RE: Response to Comments
Chick-fil-A
8811 35th Avenue, Marysville, Washington 98270
Our Job No. 17520

We have revised the plans and technical documents for the above-referenced project in accordance with your comment letter dated May 5, 2023. Enclosed are the following documents for your review and approval:

Marysville Comment Letter

**C1**

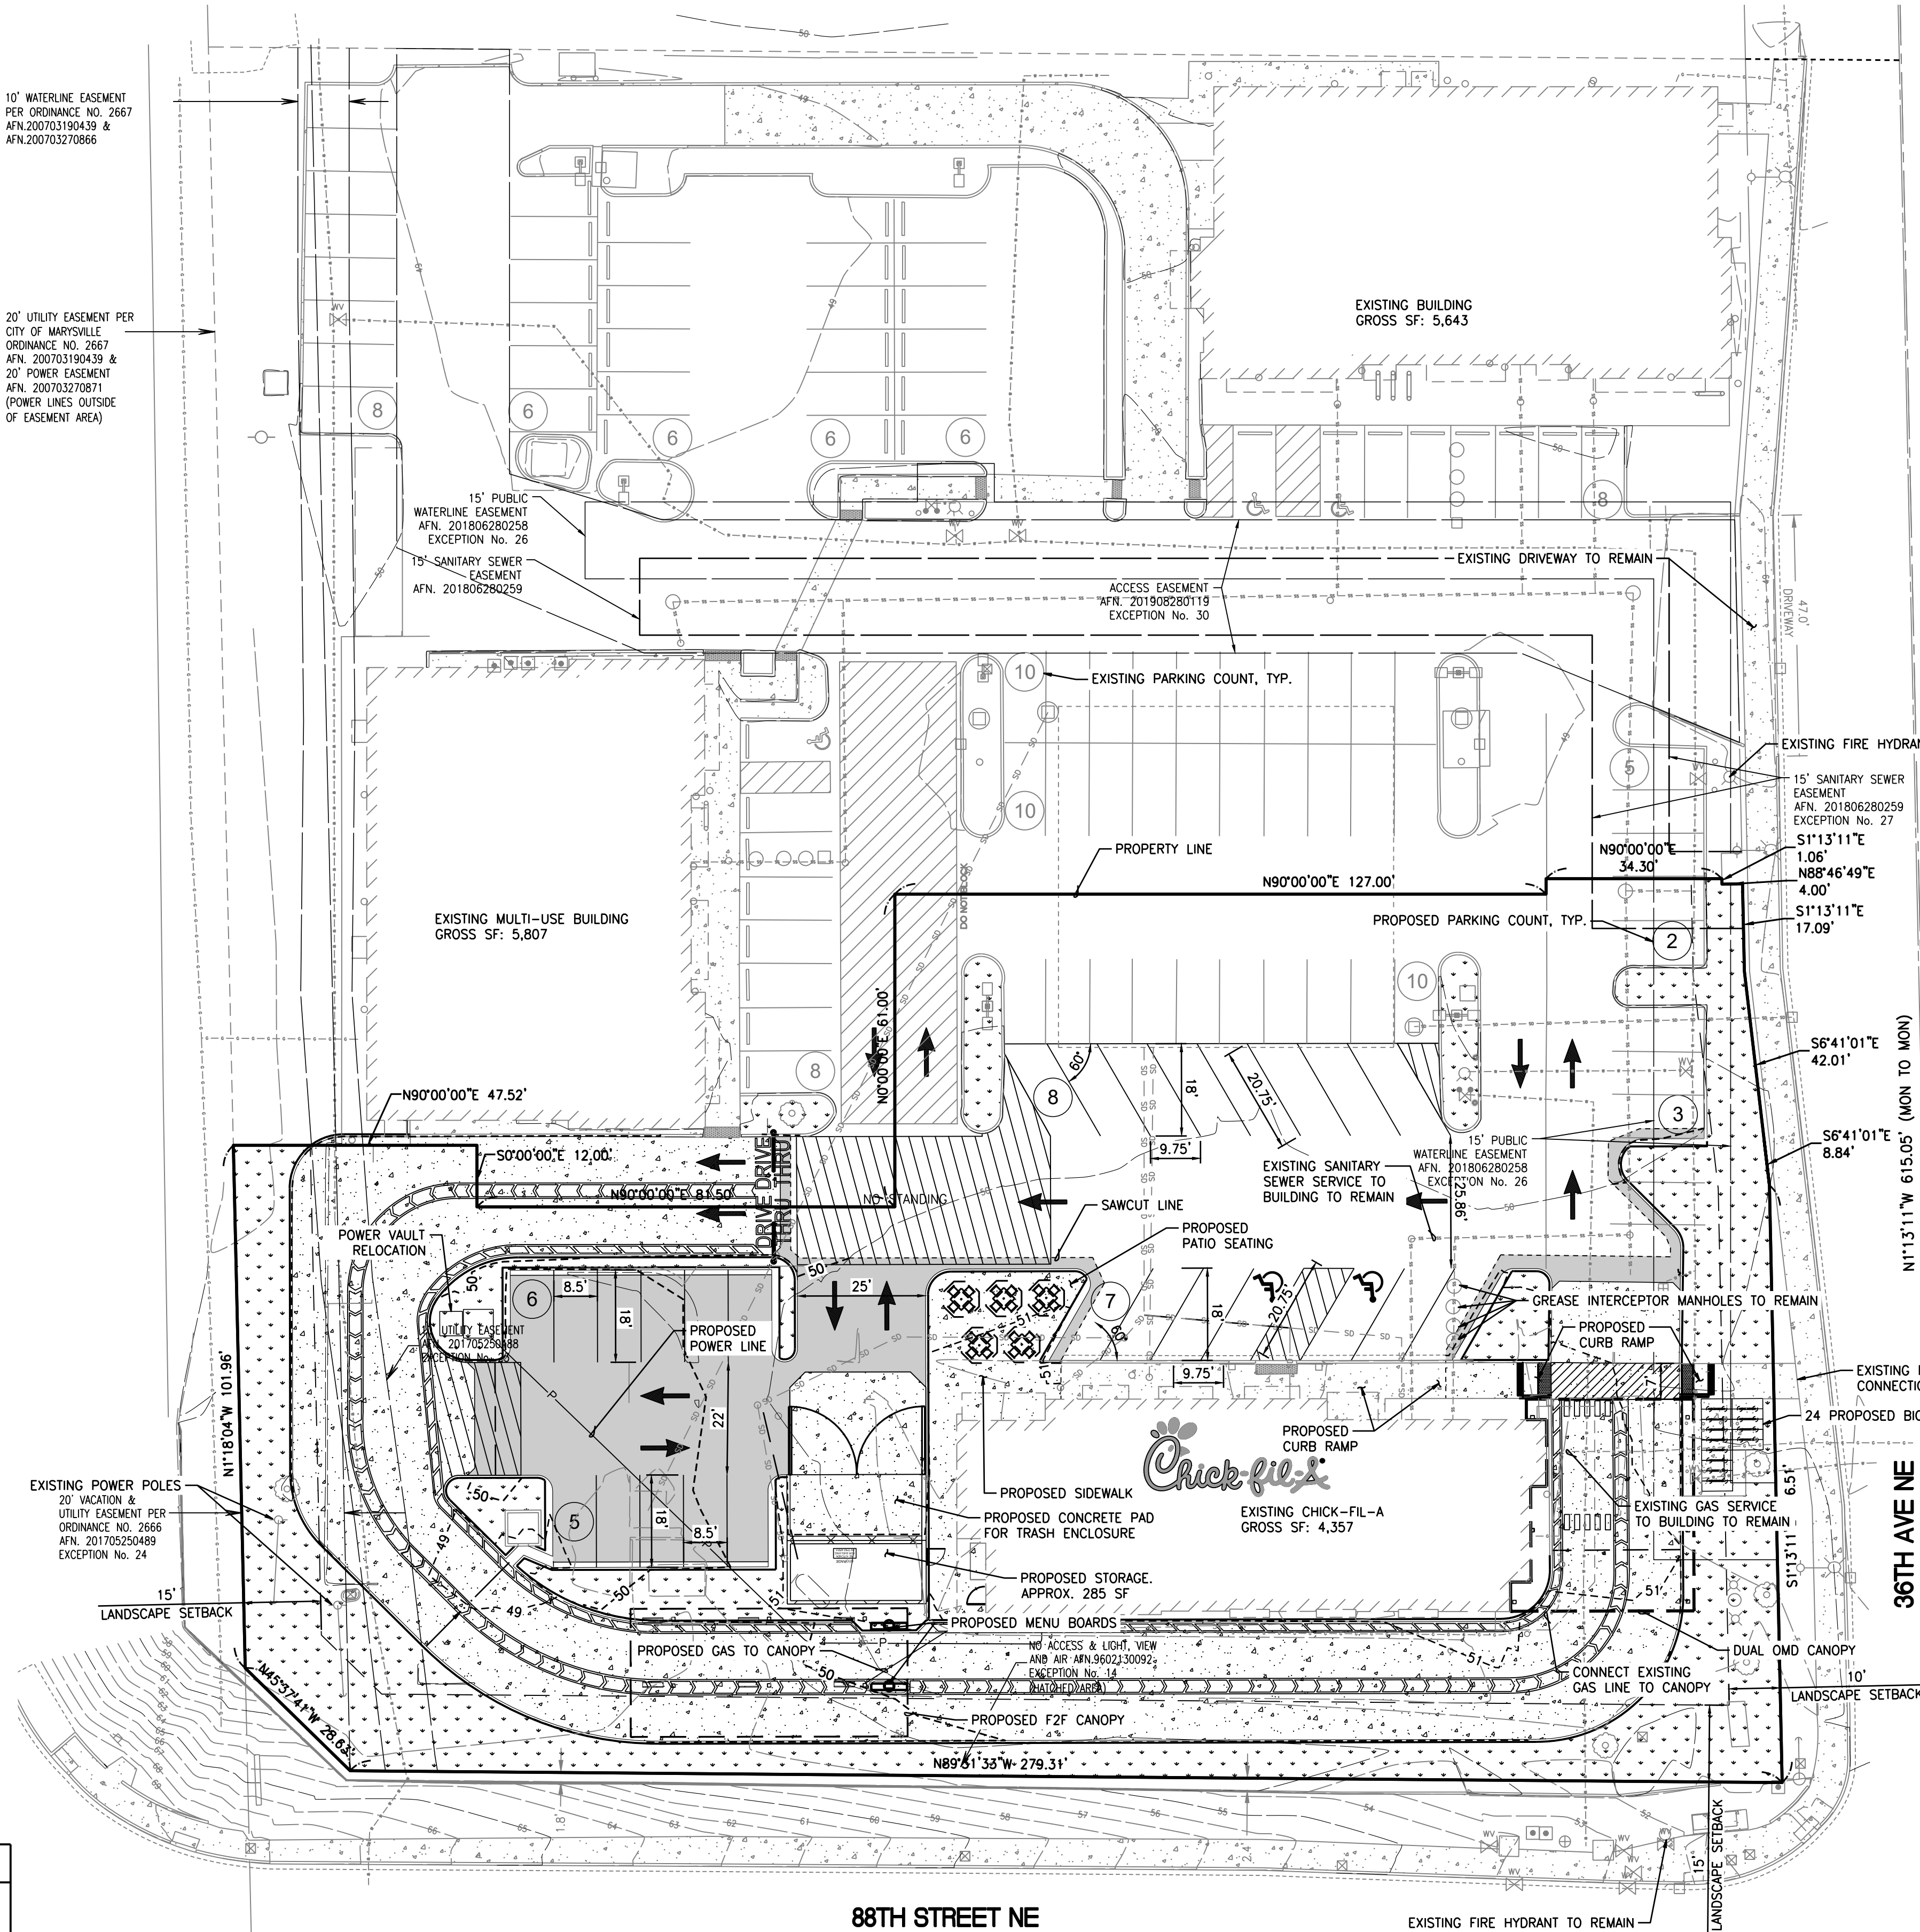
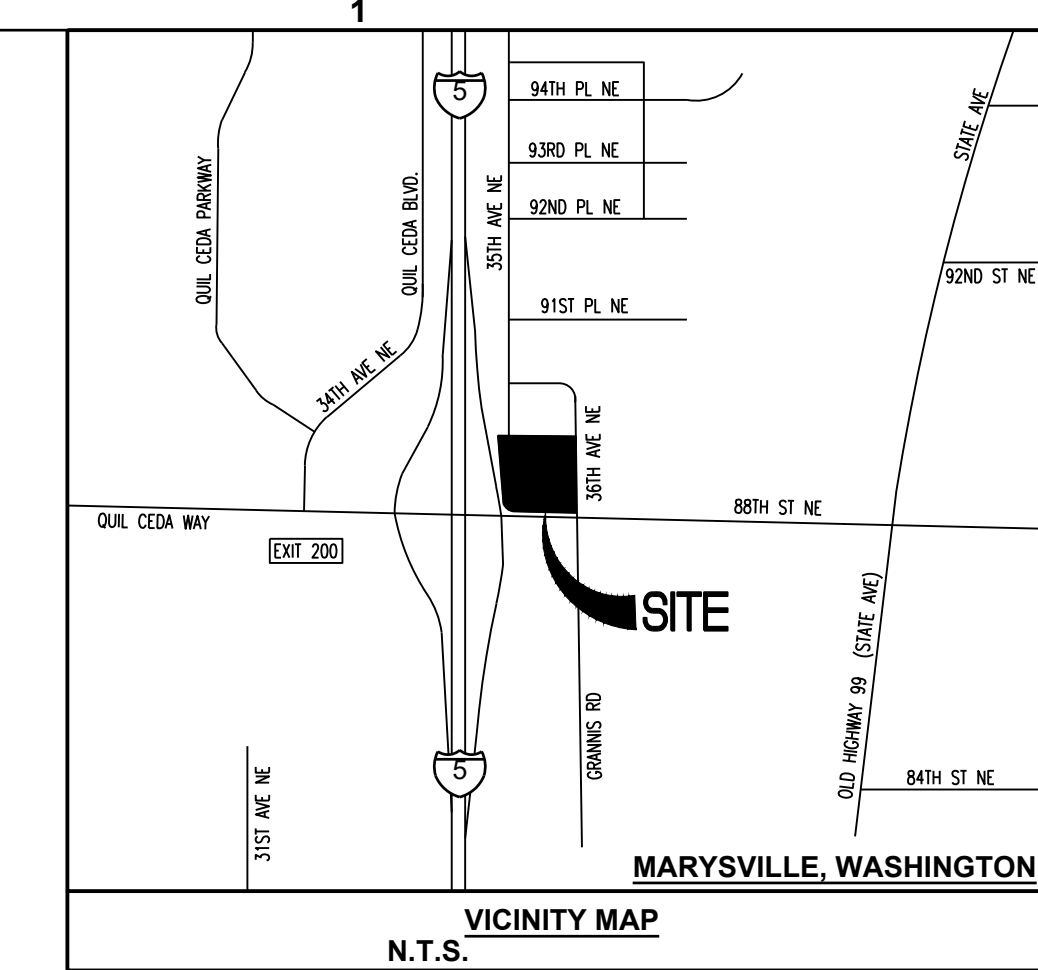
6. *The site plan shall be amended to depict and reference the applicable Auditor's File Number, of the encumbrances outlined in the Title Report, prepared by First American, dated March 22, 2023:*

- a. *City of Marysville water line easement, recorded under AFN 200703270866;*
- b. *Puget Sound Energy gas line easement, recorded under AFN 200703270869;*
- c. *PUD electrical distribution line facility easement, recorded under AFN 200703270871;*
- d. *City of Marysville utility line easement, recorded under AFN 201705250488; and*
- e. *City of Marysville utility maintenance easement, recorded under AFN 201806280258;*

7. *The site plan shall be amended, as follows:*

- a. *Provide auto-turn movement for the drive-thru and solid waste collection areas.*
- b. *Provide impervious surface calculations (maximum 85%).*

15. *The maximum allowed impervious surface coverage for the Zoning designation is 85%.*

Response: Easements referenced under 6a and 6b do not impact our site or neighboring sites. Plans have been updated to depict all on-site easements. The title report has been updated and is included with this resubmittal.

Response: The Auto-Turn movements are on sheet C4 and the impervious calculations are found on C1 of the plans included with this resubmittal.

Response: Our site is under the maximum impervious coverage, and quantities are listed on sheet C1 included with this resubmittal.
